APPROVED - SECOND FLOOR PLAN PL002 REV P02

PROPOSED AMENDED LAYOUT

Summary of Changes

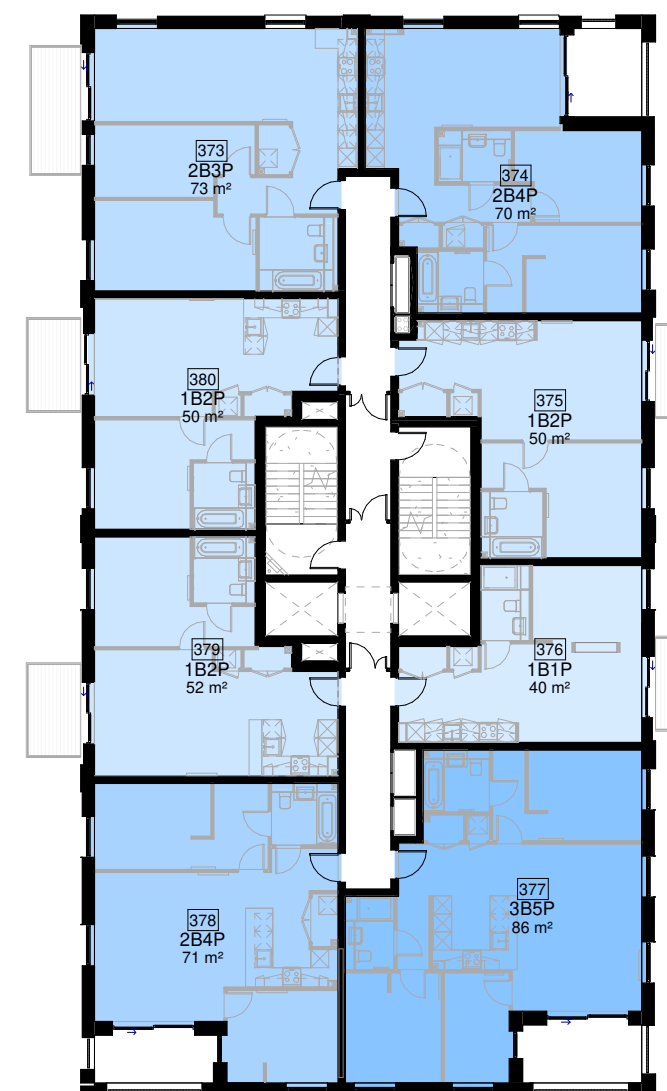
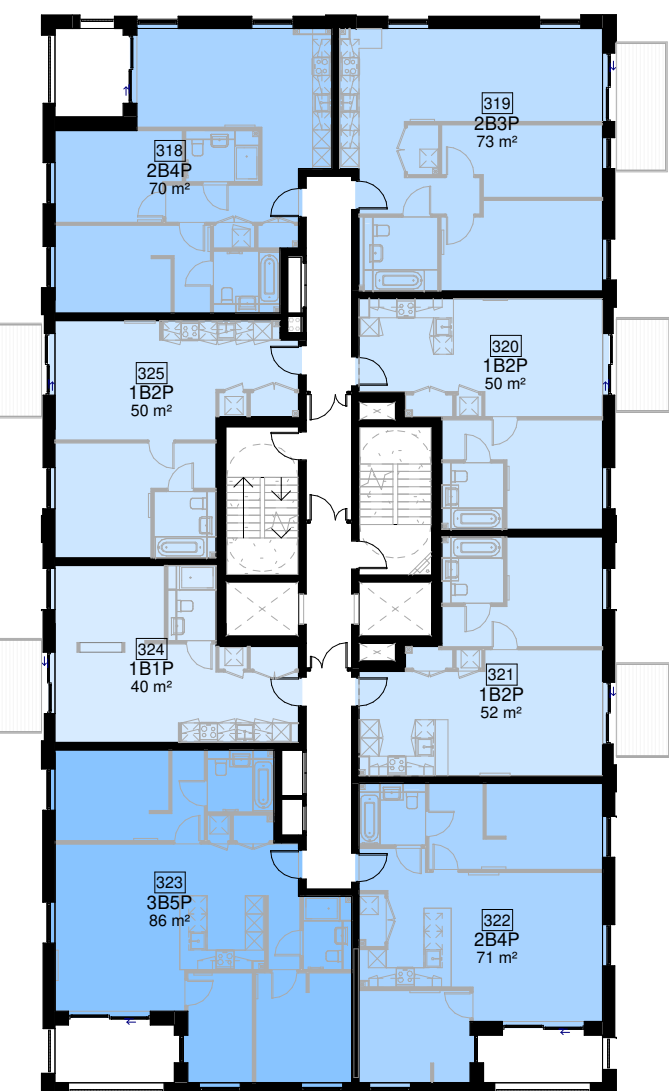
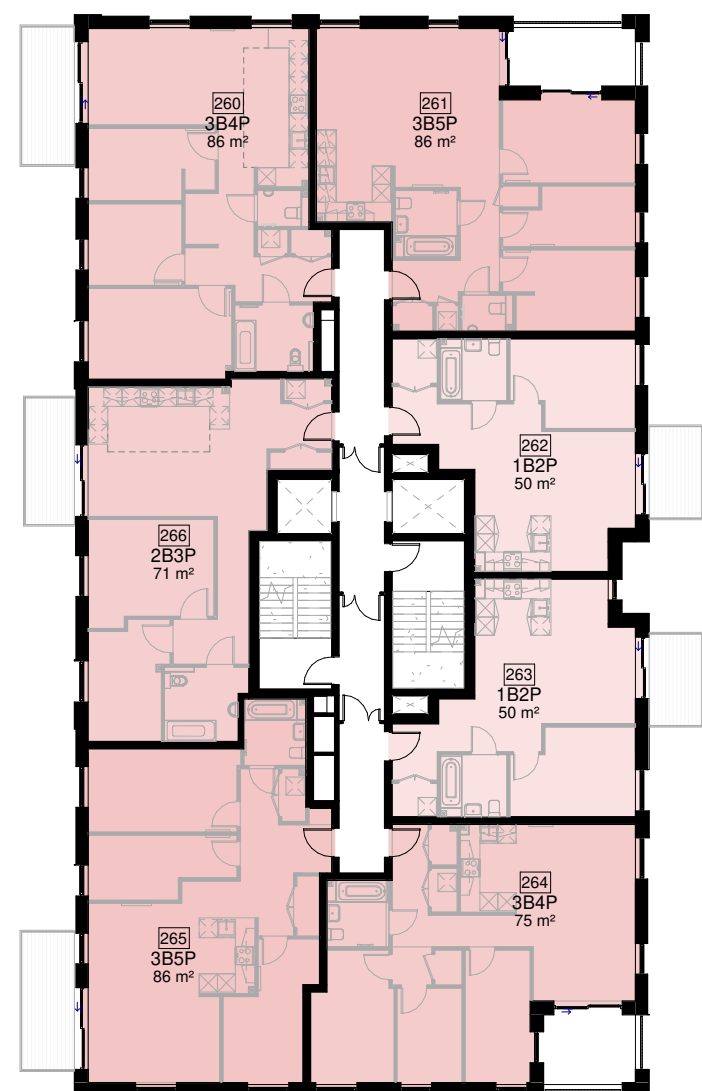
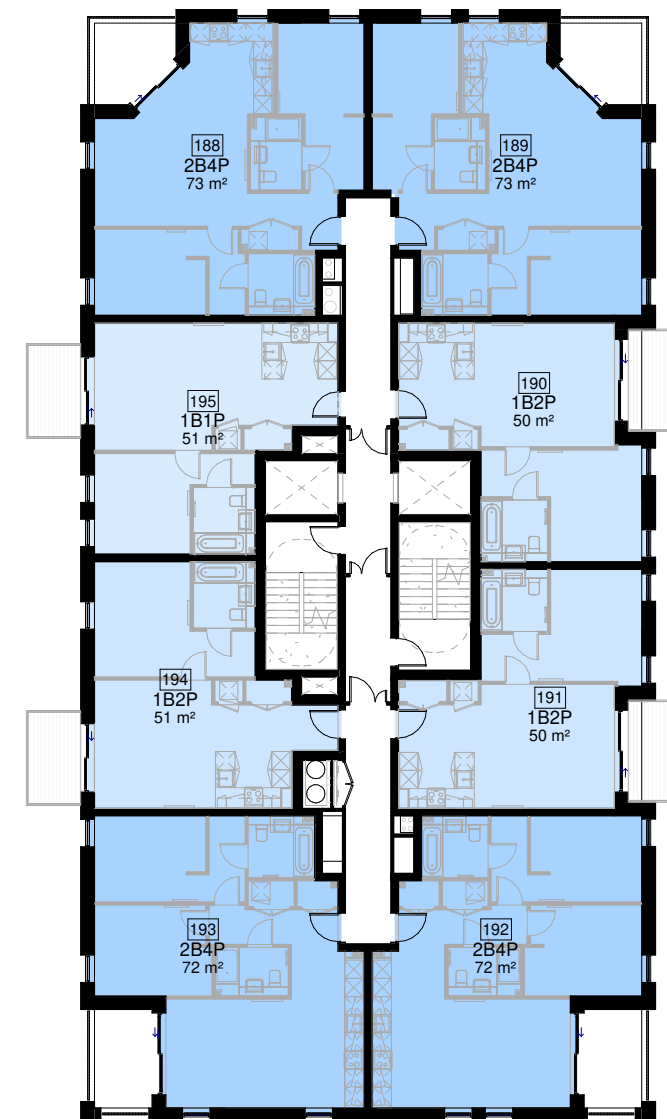
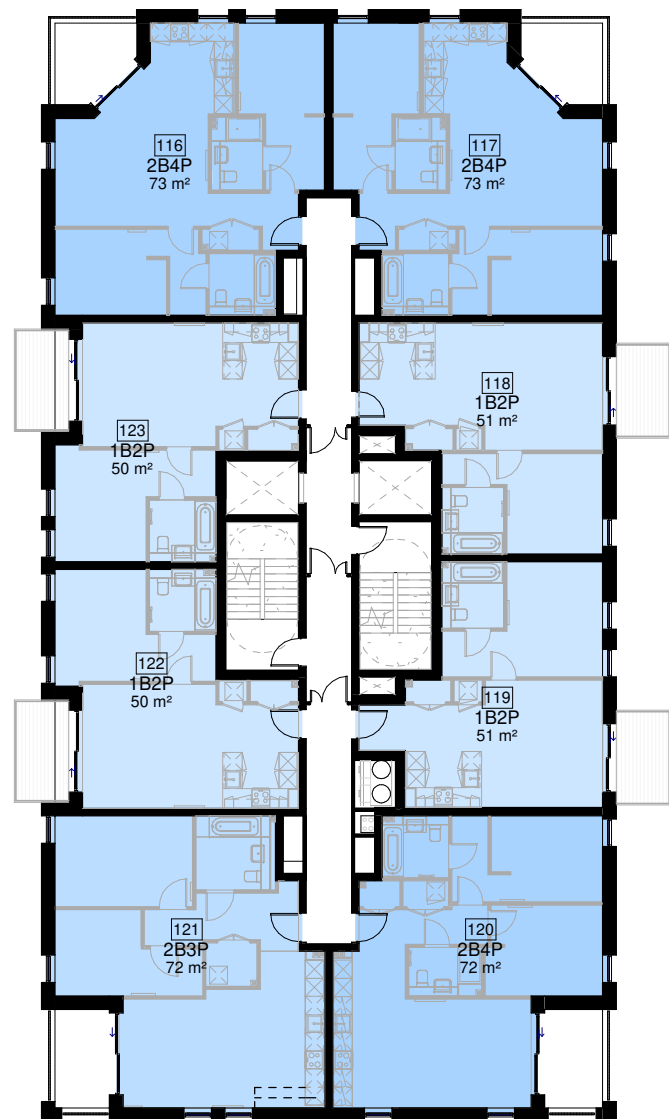
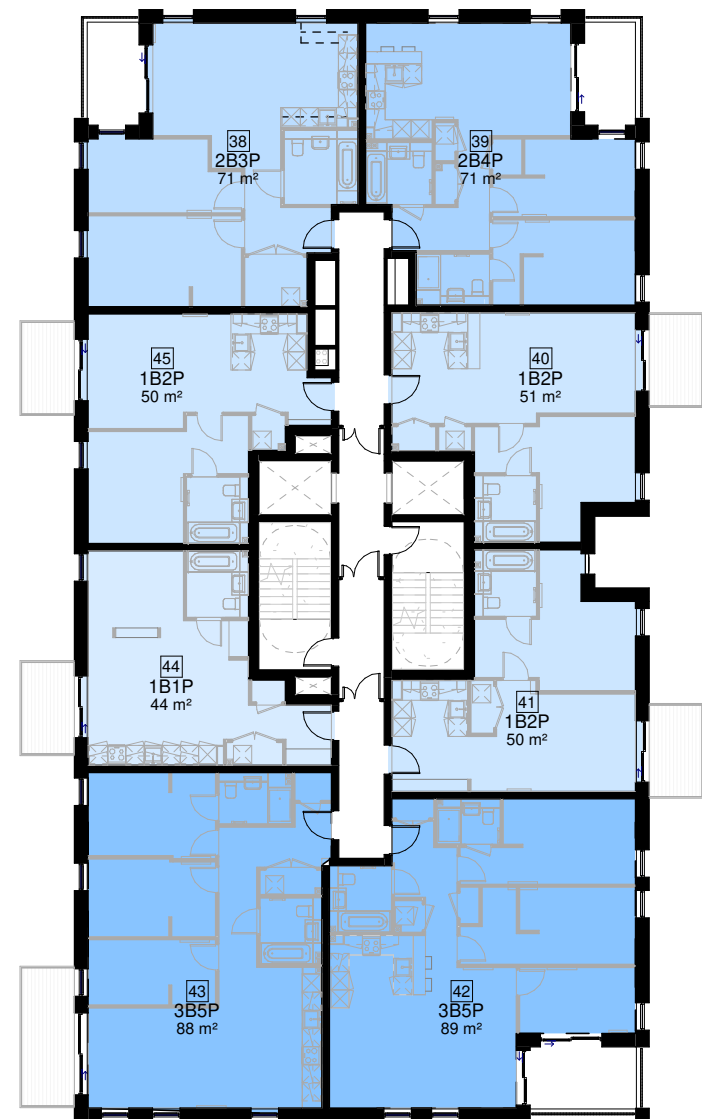
1. Second escape stair added to all cores to provide a secondary means of escape for all residents in the event of a fire. Adjacent homes, risers etc all adjusted to suit.
2. Nominal changes to balconies and facade to ensure that internal flat layouts retain compliance with future fire regulations and ensure escape past hob distances are reduced where possible as advised by JGA Fire.

WING NAME
Seventh Floor Plan

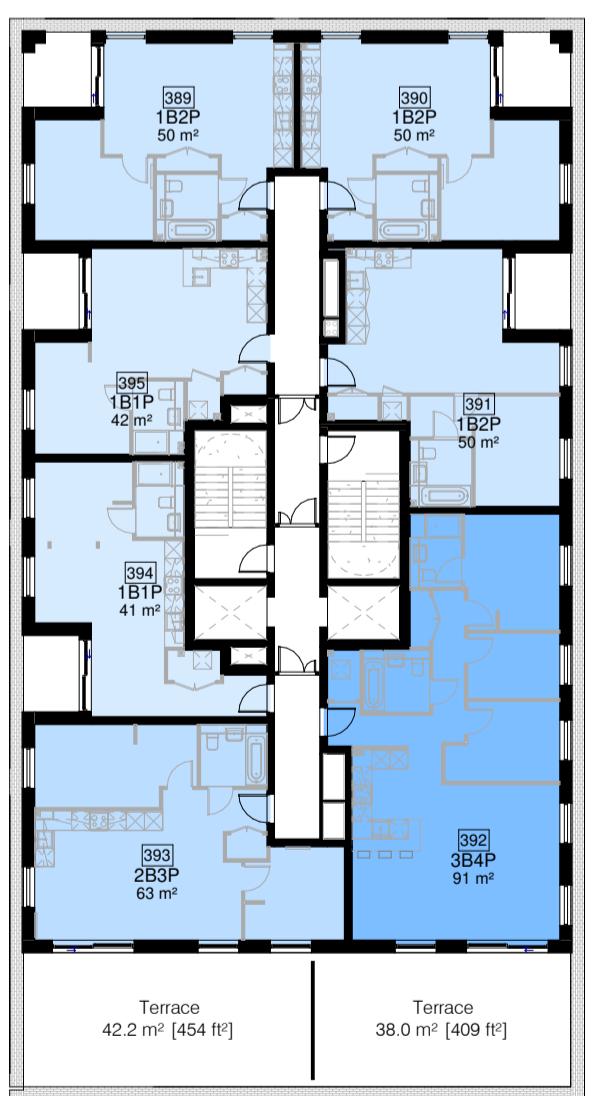
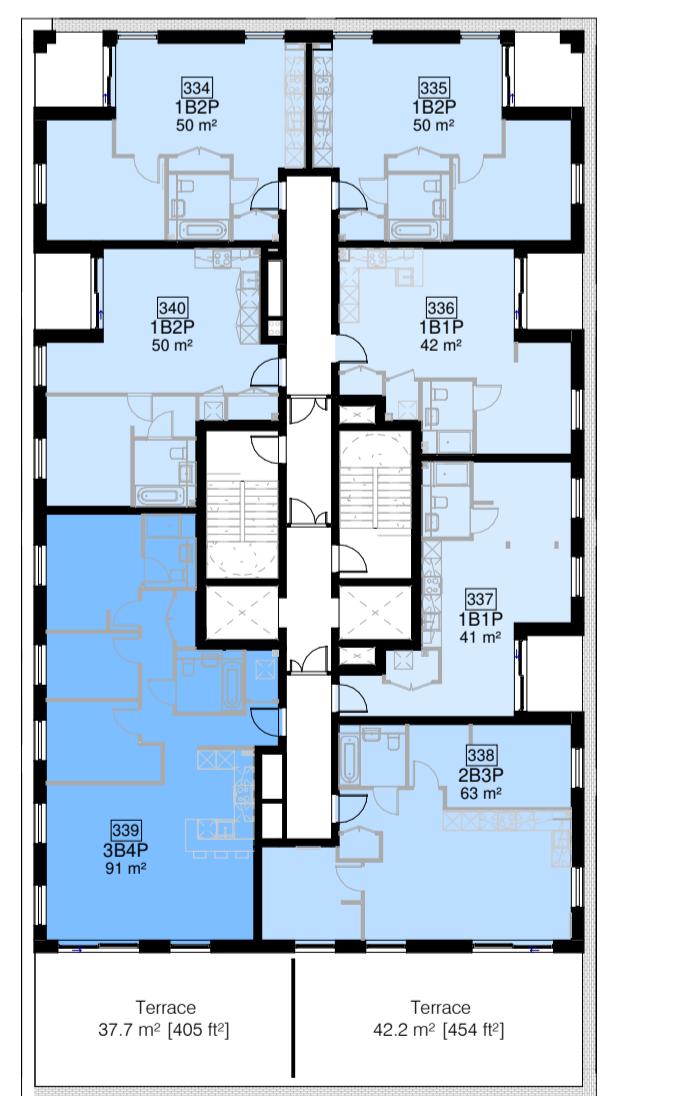
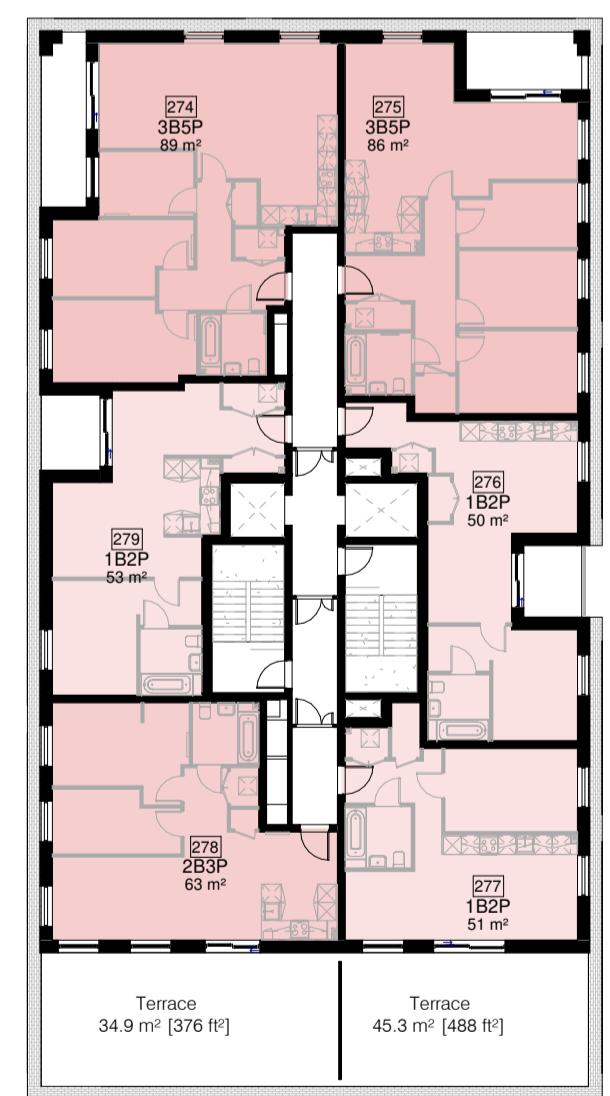
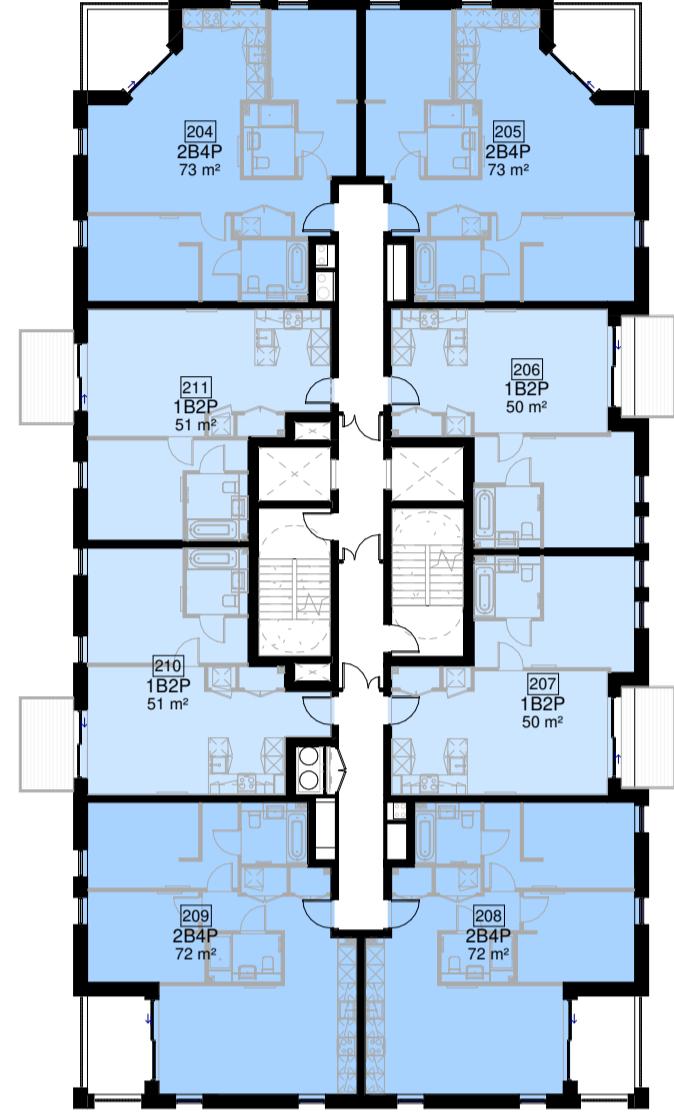
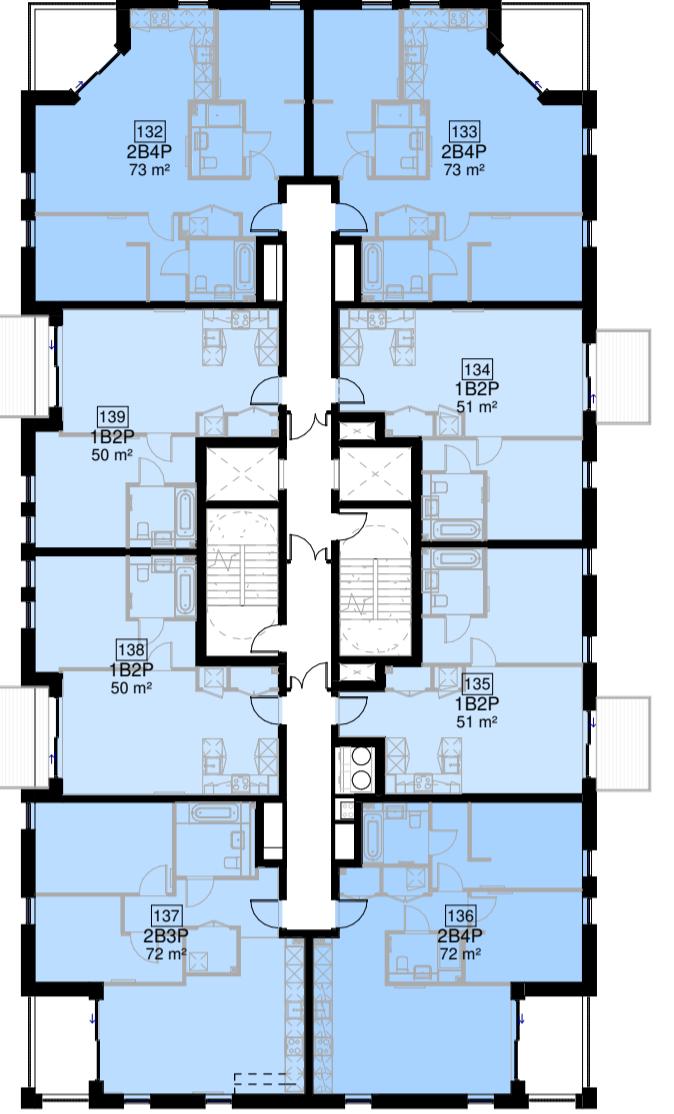
1. Second escape stair added to all cores to provide a secondary means of escape for all residents in the event of a fire. Adjacent homes, risers etc all adjusted to suit.
2. Nominal changes to balconies and facade to ensure that internal flat layouts retain compliance with future fire regulations and ensure escape past hob distances are reduced where possible as advised by JGA Fire.
- Note - overall change in occupancy is required to allow for the additional stairs to be added. Generally this is done by a reduction of 1B2P homes to 1B1P homes. There is no proposed change to the number of family sized dwellings.
